| Consultation Response from KC, Highways Development Management | | |
| 2021/93644 Low Farm, Wakefield Road, Flockton, Huddersfield, WF4 4BB | | |
| Erection and operation of grid-connected solar photovoltaic farm, with ancillary infrastructure and landscaping and biodiversity enhancements | | |
| Date Responded:27-10-2021 | Responding Officer: Mark Berry | Responding Ref: 16-15-13 |

Figure 4.2 Proposed Site Access Points

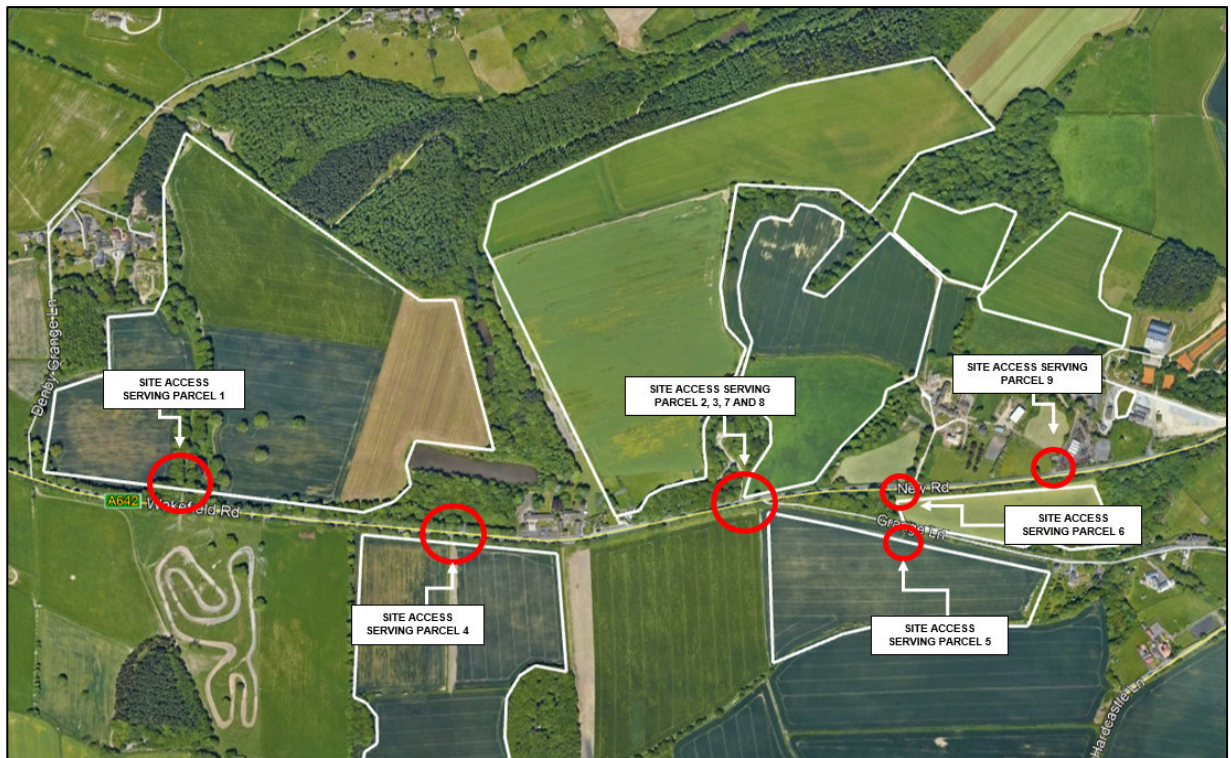
Can the applicants explain why a John Deere Tractor and Rolland Trailer has been used for accesses serving parcels 2 to 8 and not a 16.5 m articulated lorry. The largest vehicle anticipated to use these accesses during the construction period should be tracked.
